**Consultation Response from KC,
Trees**
2023/93059 Land off, Staincliffe Road, Dewsbury Moor, Dewsbury, WF13 4RD
Erection of light industrial units
Date Responded: 23/22/2023
Responding Officer: D. Atkinson
Responding Ref: 33a/96/g20

1 PROPOSED SITE PLAN
1 : 200

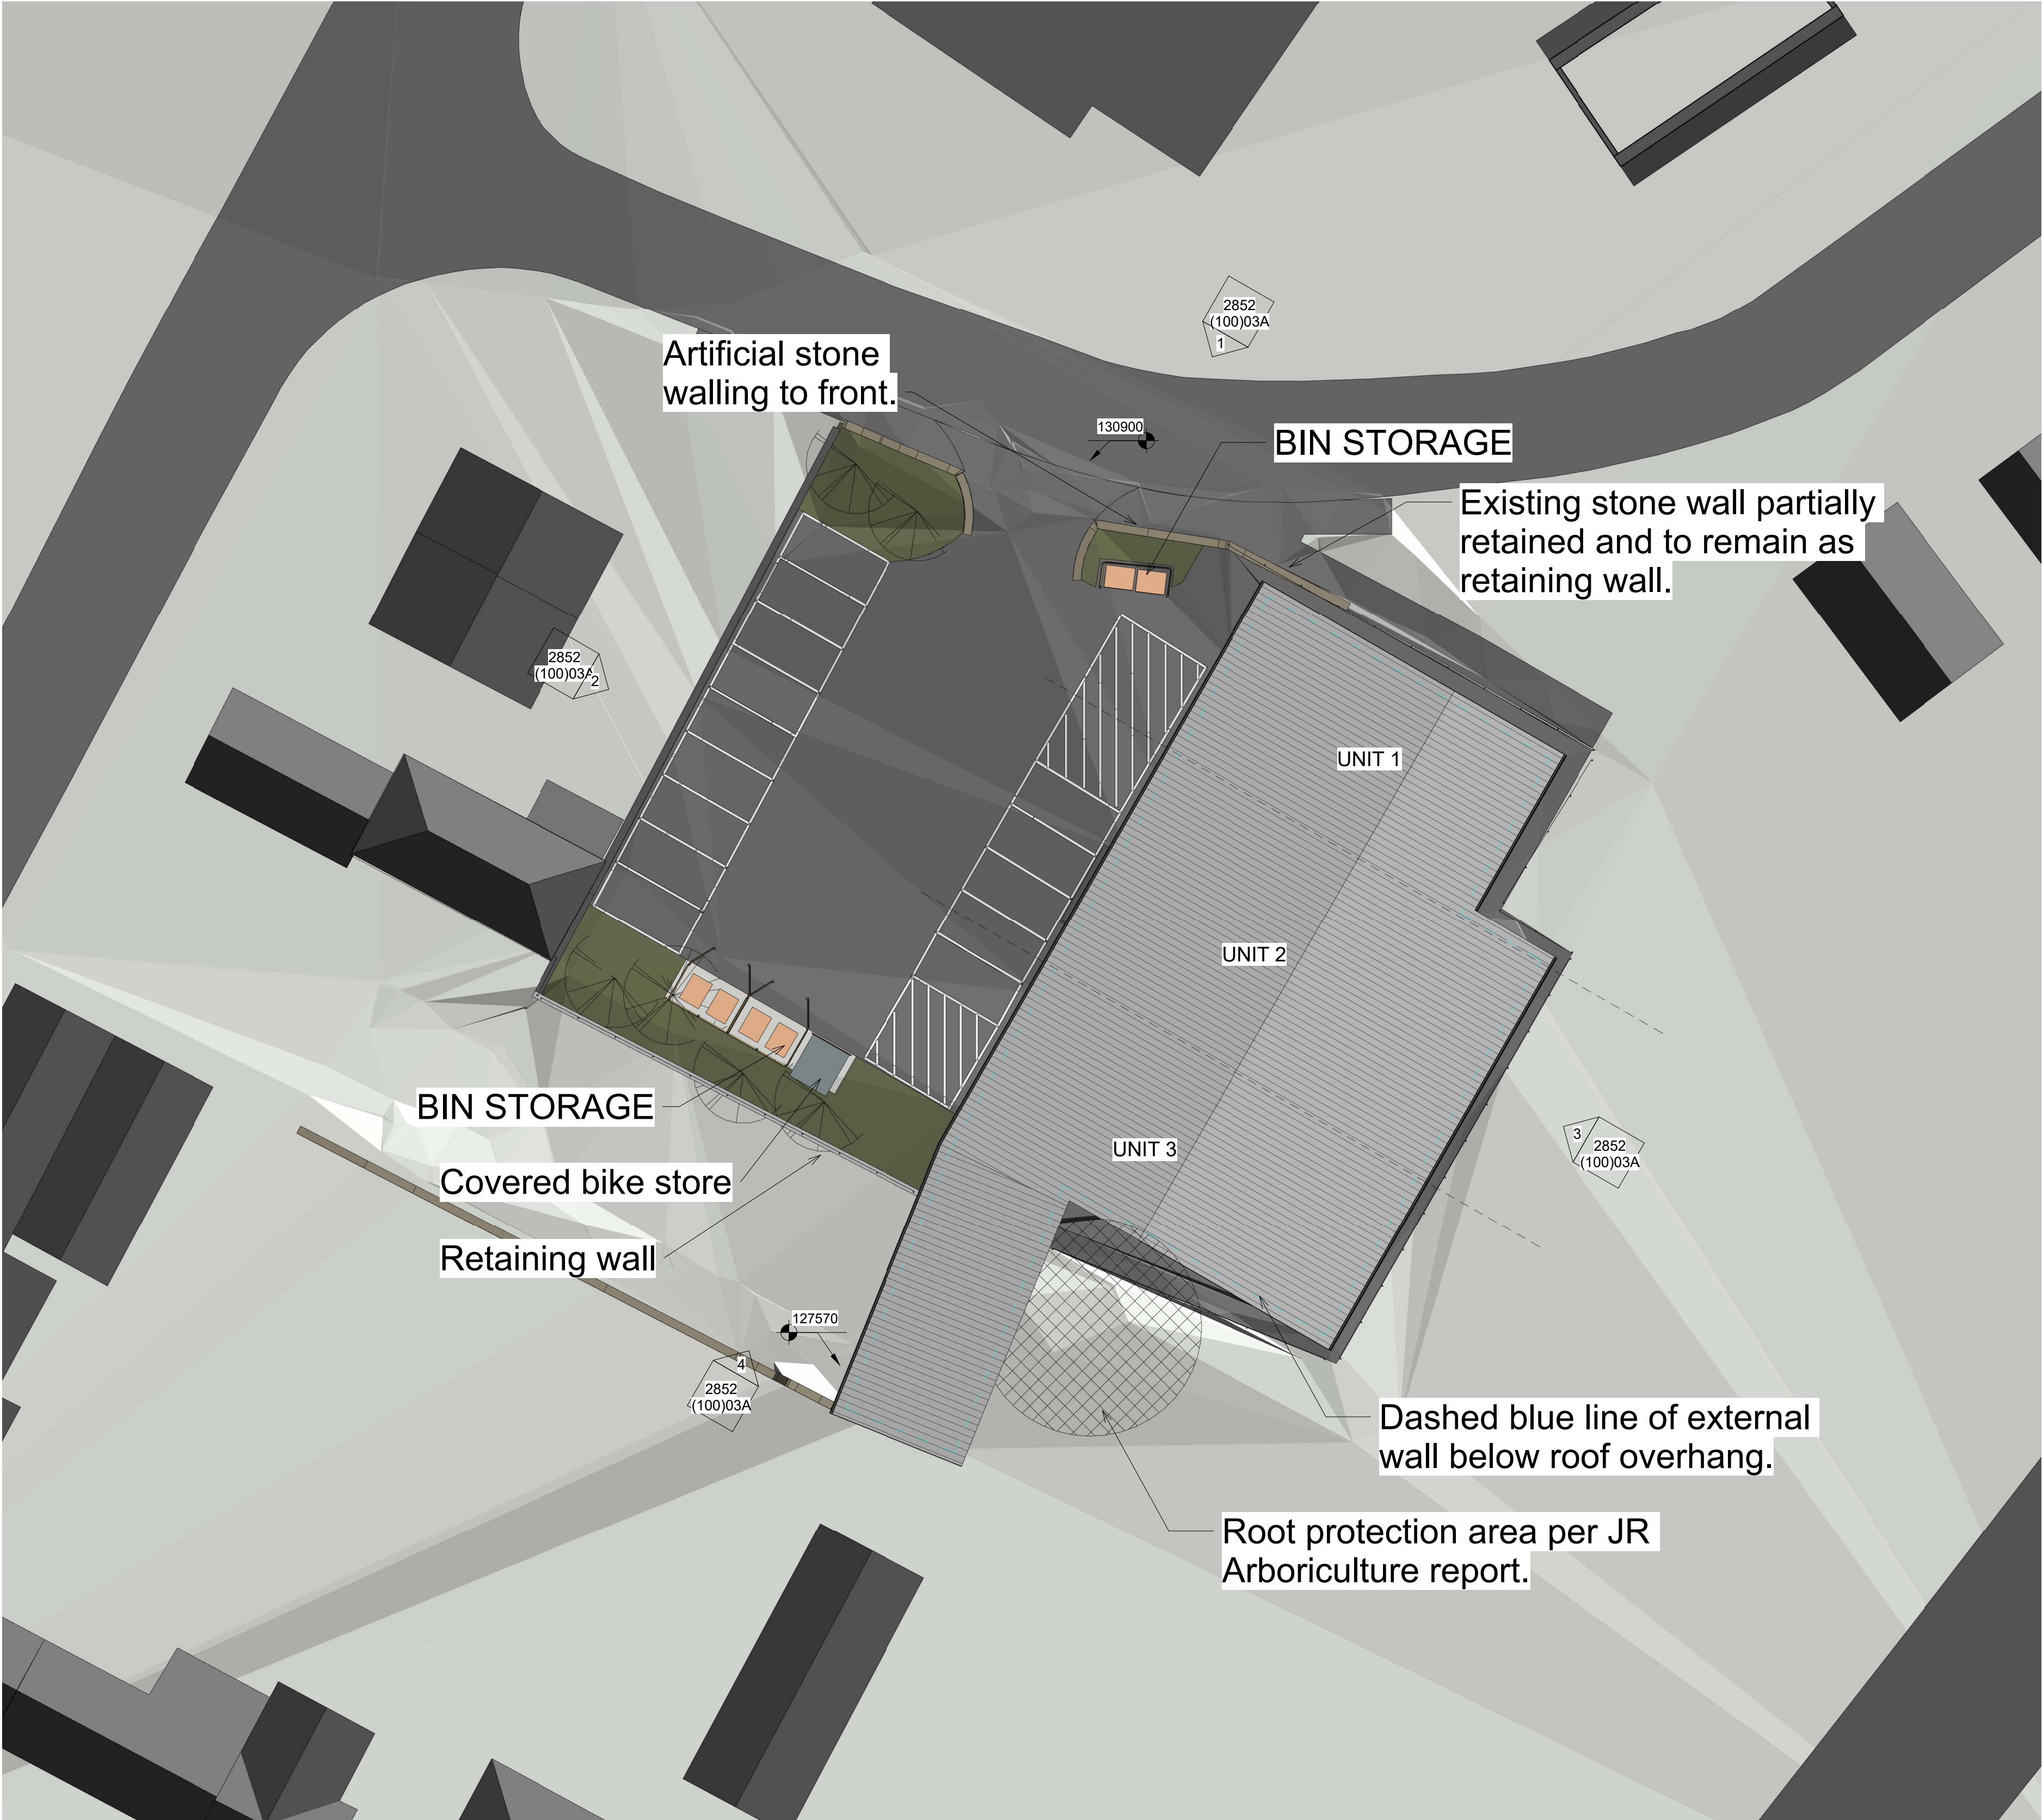
The proposed development site is constrained by existing trees on neighbouring land that is immediately adjacent that are protected by Tree Preservation Order 33a/96/g20 and 33a/96/g21

Proposed unit 1 and 2 appear like they could impact on 33a/96/g21 and unit appear to likely impact on 33a/96/g20.

Because there isn't any arboriculture information provided with the application and it appears foreseeable that the adjacent protected tree would be impacted by the development. There is an objection to the proposal as it is conflicting with Policy LP33 of the adopted Kirklees Council Local Plan for appearing to not comply with relevant national standards regarding the protection of trees in relation to design, demolition and construction.

The retention of trees, shrubs and hedgerows that are present on or adjacent to a site is a consideration whether or not they are protected. As a result, a tree survey and Arboriculture Impact Assessment (AIA) following the guidance in BS5837:2012 Trees in Relation to Design, Demolition and Construction will be needed that has been completed by a suitably experienced and qualified arboriculture consultant.
